MEMORANDUM

SUBJECT: SP-20-008 – Homestead North - Sterling Ranch
Third Submittal

Engineering Division

COVER SHEET

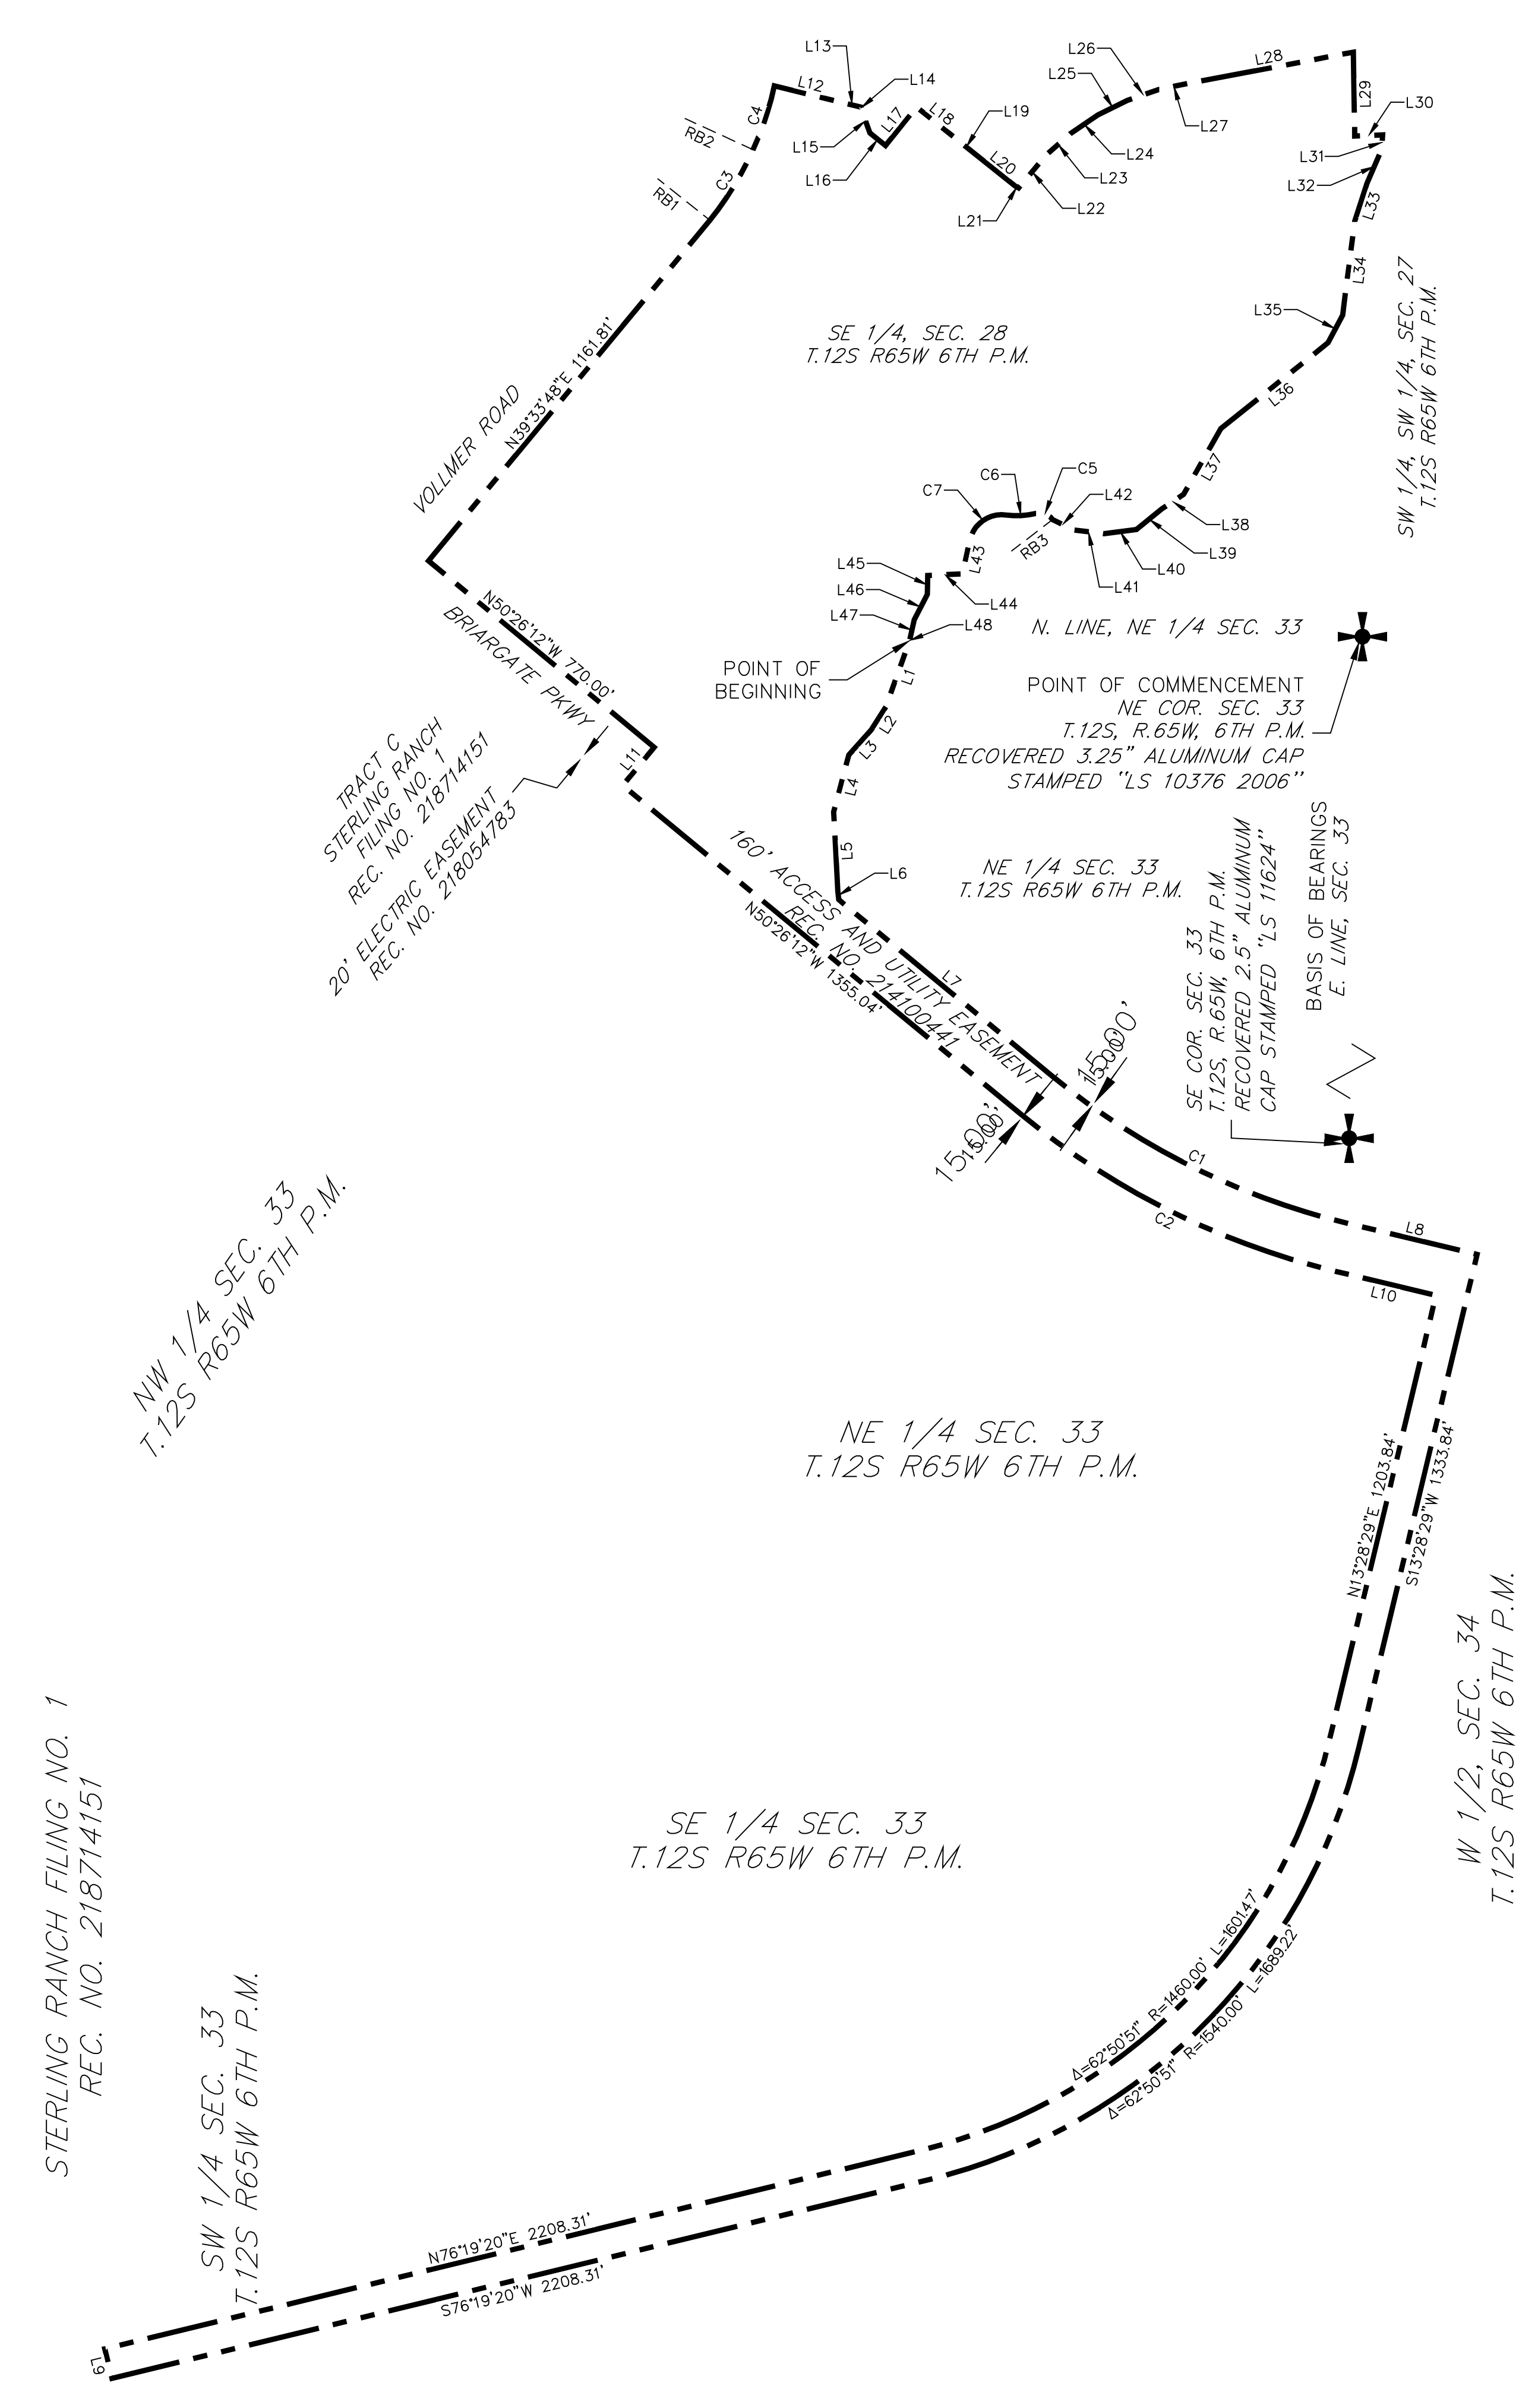
2. Provide proposed road cross-sections. Resolved; see redlines on the cross-sections. **Partially resolved – add the proposed new one-way cross-section. Address whether noise walls will be provided for the two adjacent lots based on how close the road is to the building envelopes, and whether a height restriction is needed on the south lot to allow sunlight to reach the road in winter, to prevent icing conditions.**

Response: Proposed one-way cross section provided on Cover Sheet. Noise study has been updated and uploaded to EDARP. Noise walls are not recommended for Jane Kirkham Drive. A height restriction is not needed. Lots and setbacks are proposed in similar configurations on site.

PRELIMINARY PLAN

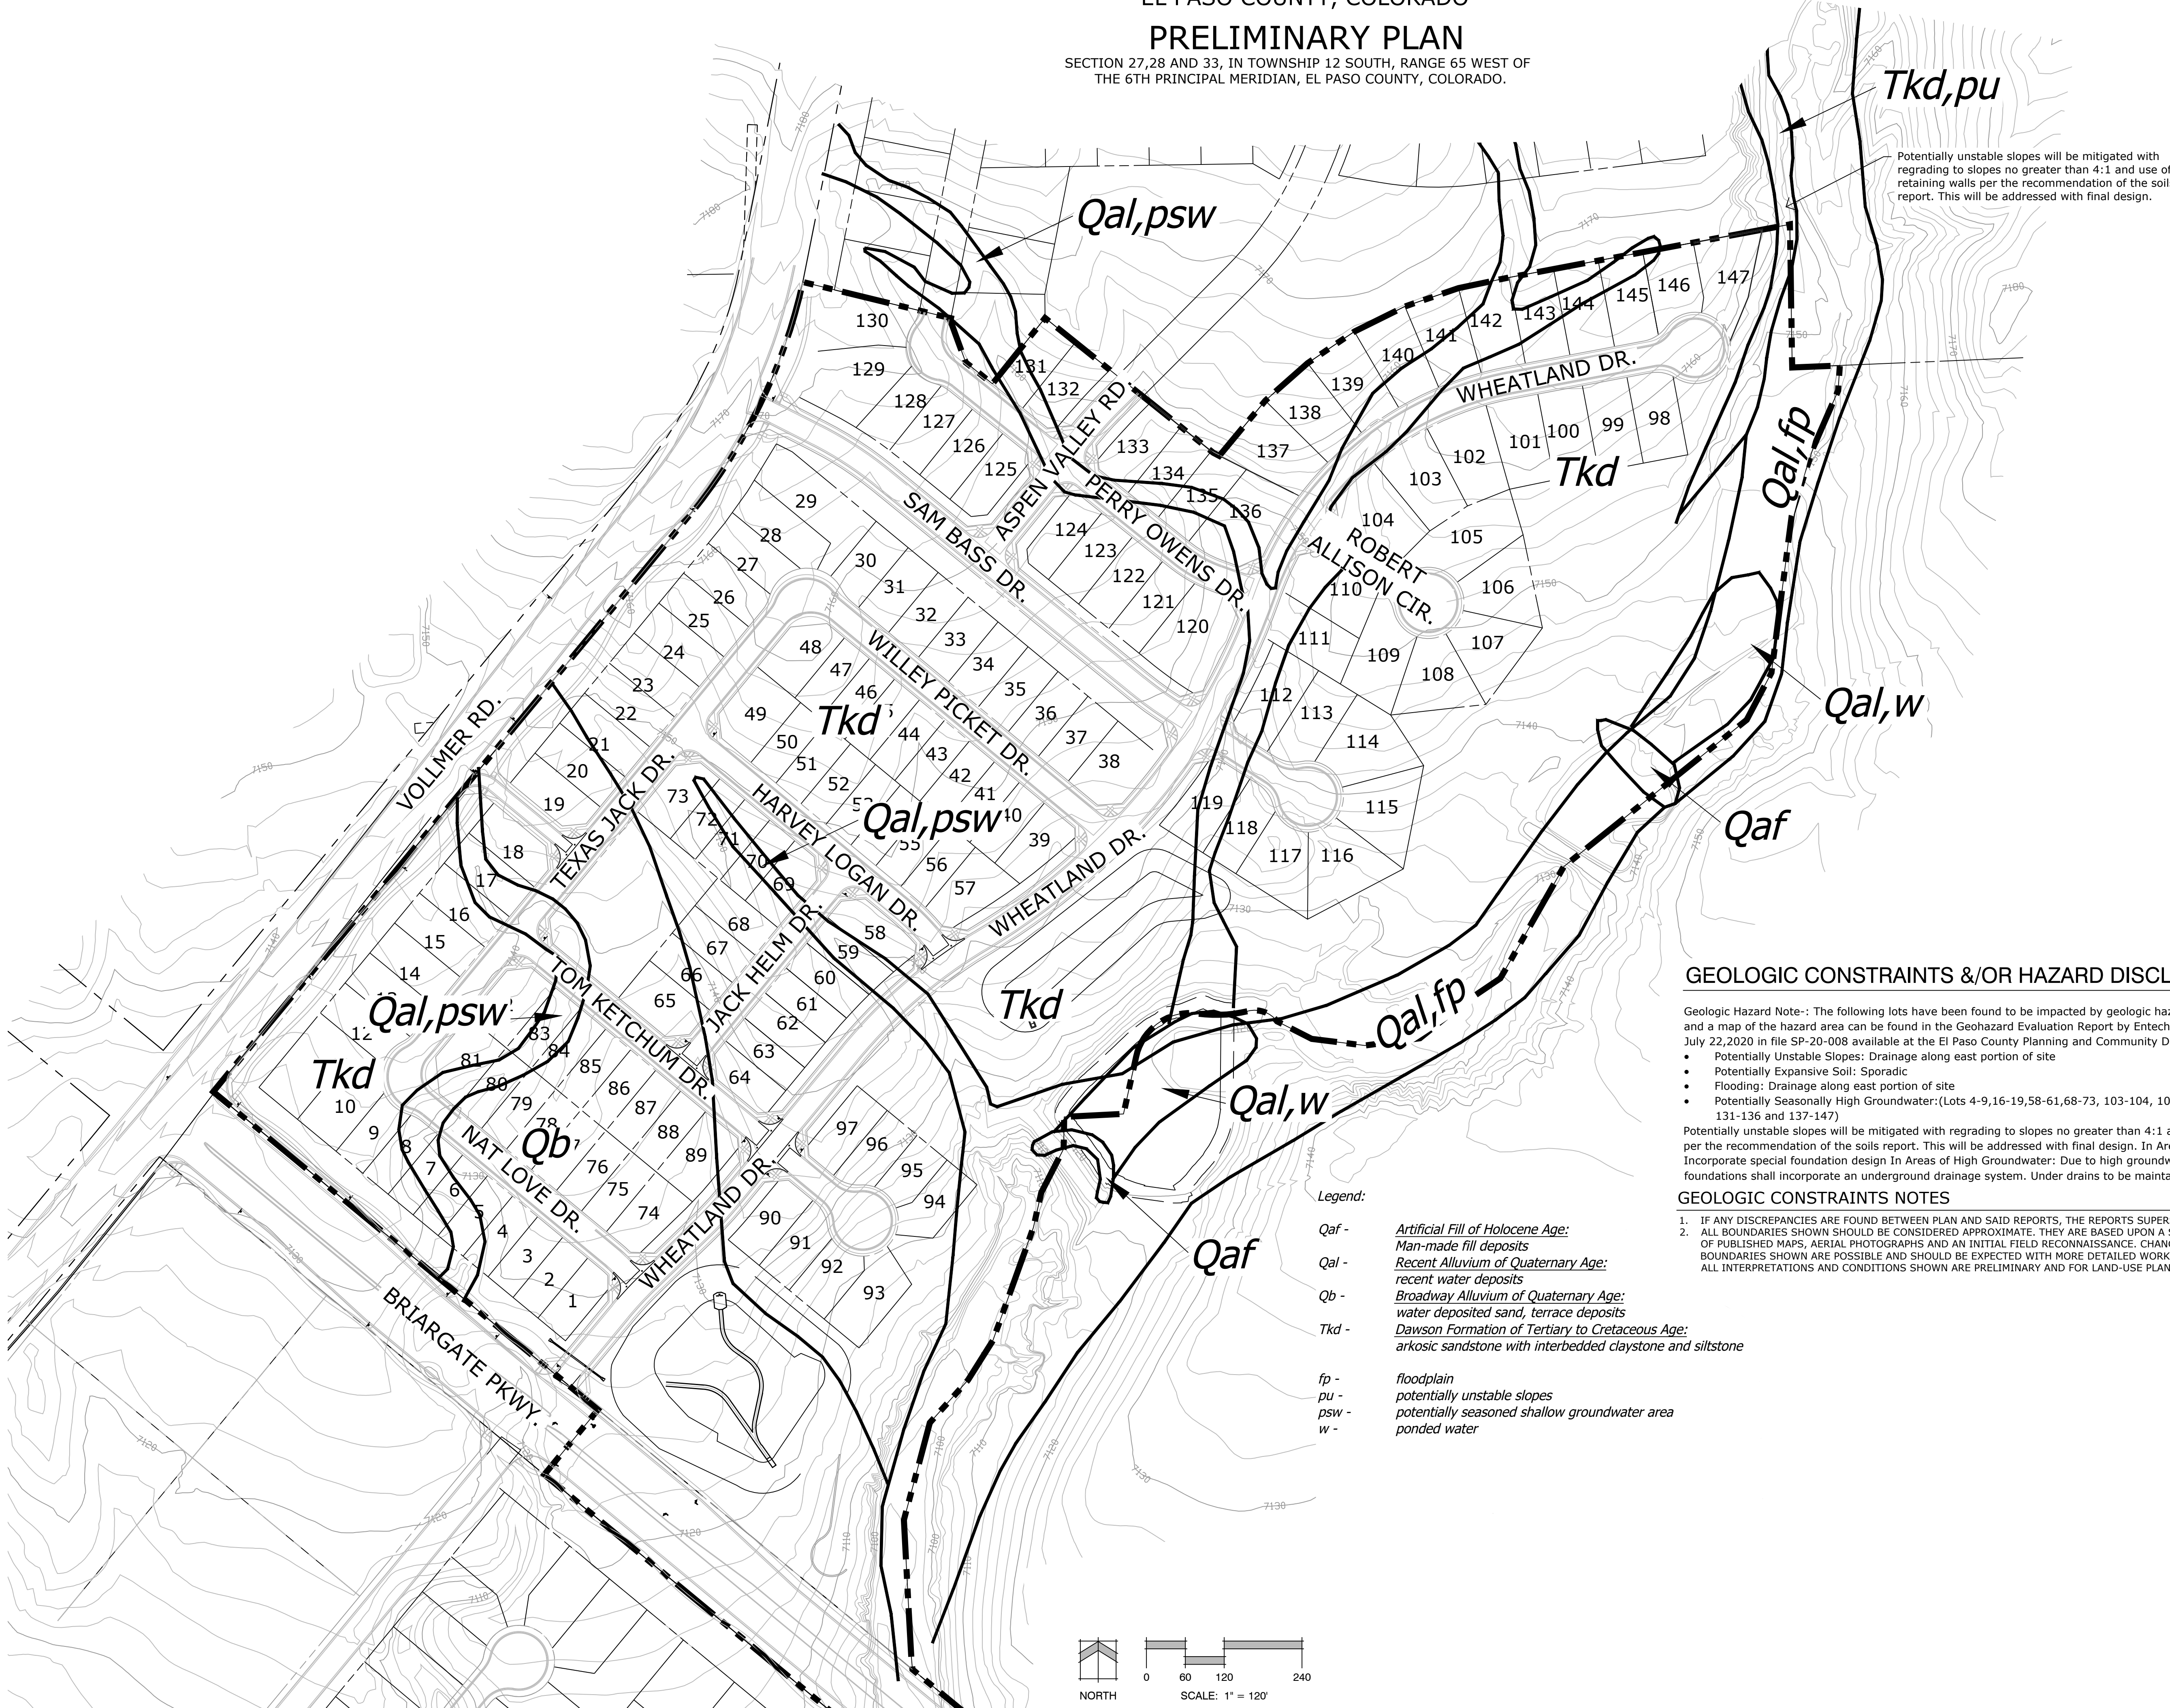
9. **Resolved.**
10. **Address how the potentially unstable areas along Sand Creek at the northeast corner of the site will be stabilized. This comment is in regard to the Soils and Geology study showing the west bank of Sand Creek from Wheatland north being potentially unstable. A statement in the PDR narrative about this will be sufficient.**

JR Response: Addressed, potentially unstable slope will be mitigated with proposed grading not steeper than 4:1 and the use of retaining walls per the recommendation of the soil report.

HOMESTEAD NORTH AT STERLING RANCH
EARLY GRADING & EROSION CONTROL PLAN

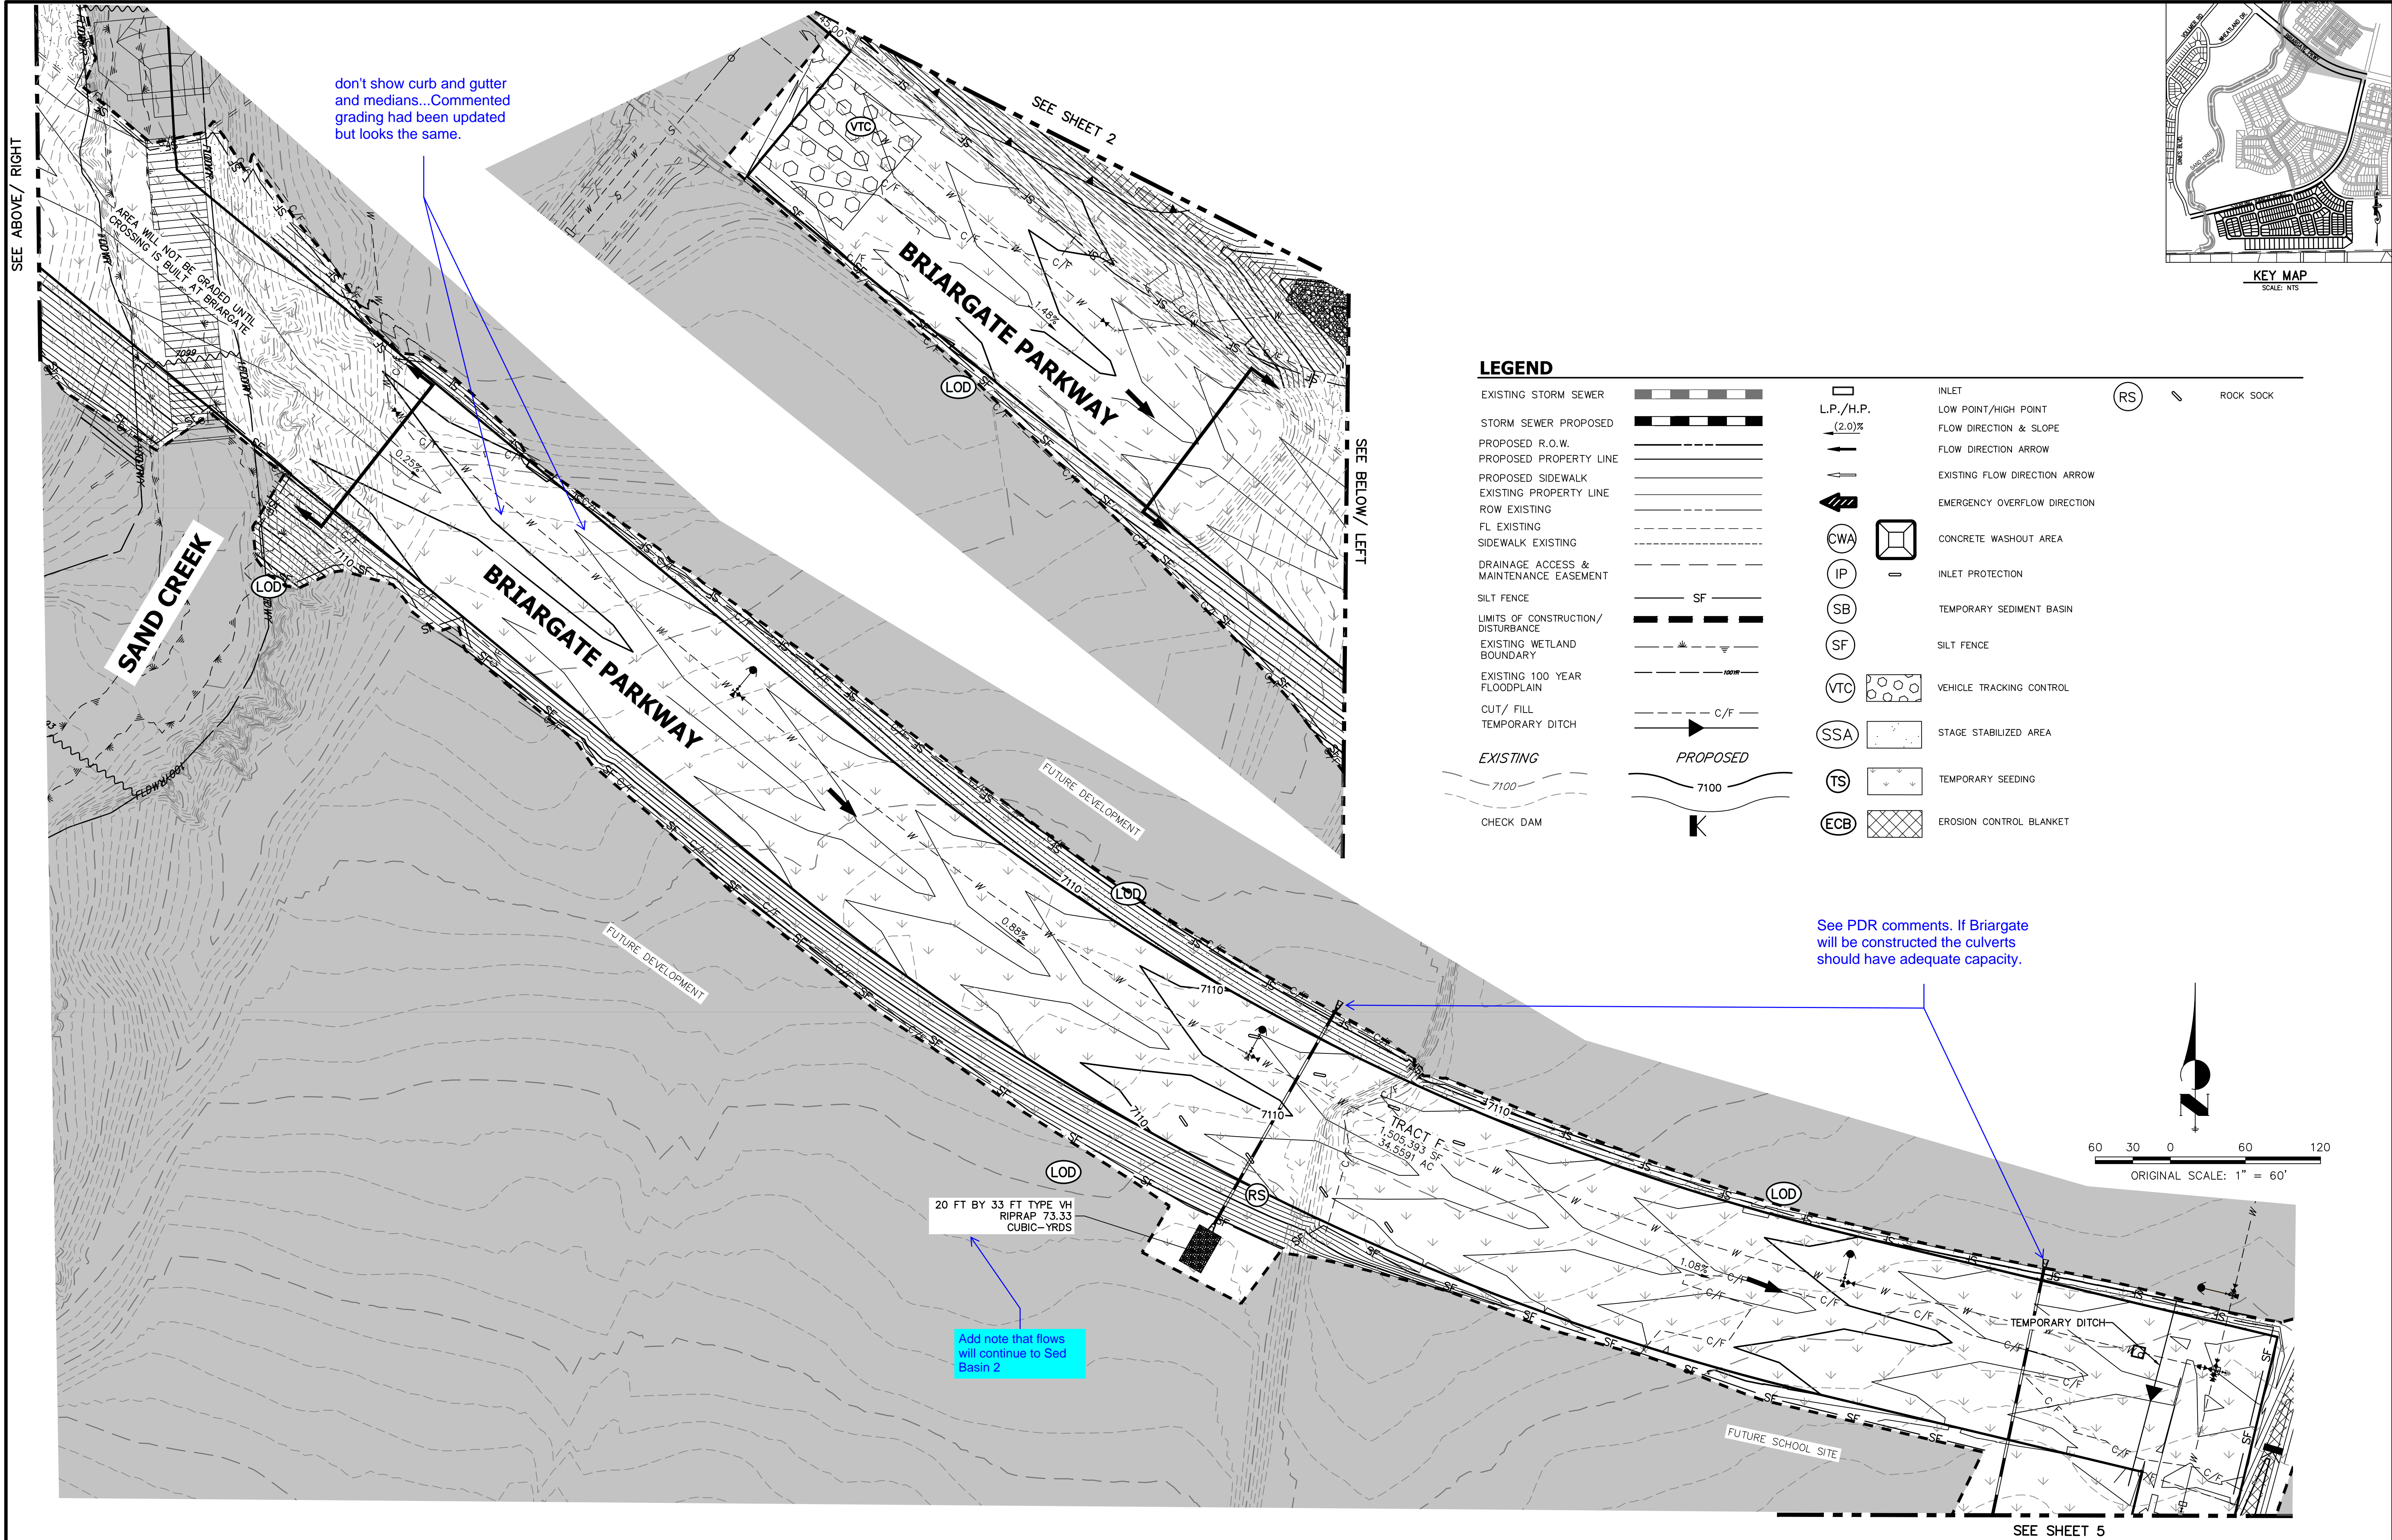
Also provide a drainage plan for the interim pre-development site grading not showing curb and gutter and showing temporary facilities. This should match the grading shown on the early grading and erosion control plan. **Partially resolved; see redlines.**
JR Response: Redlines addressed
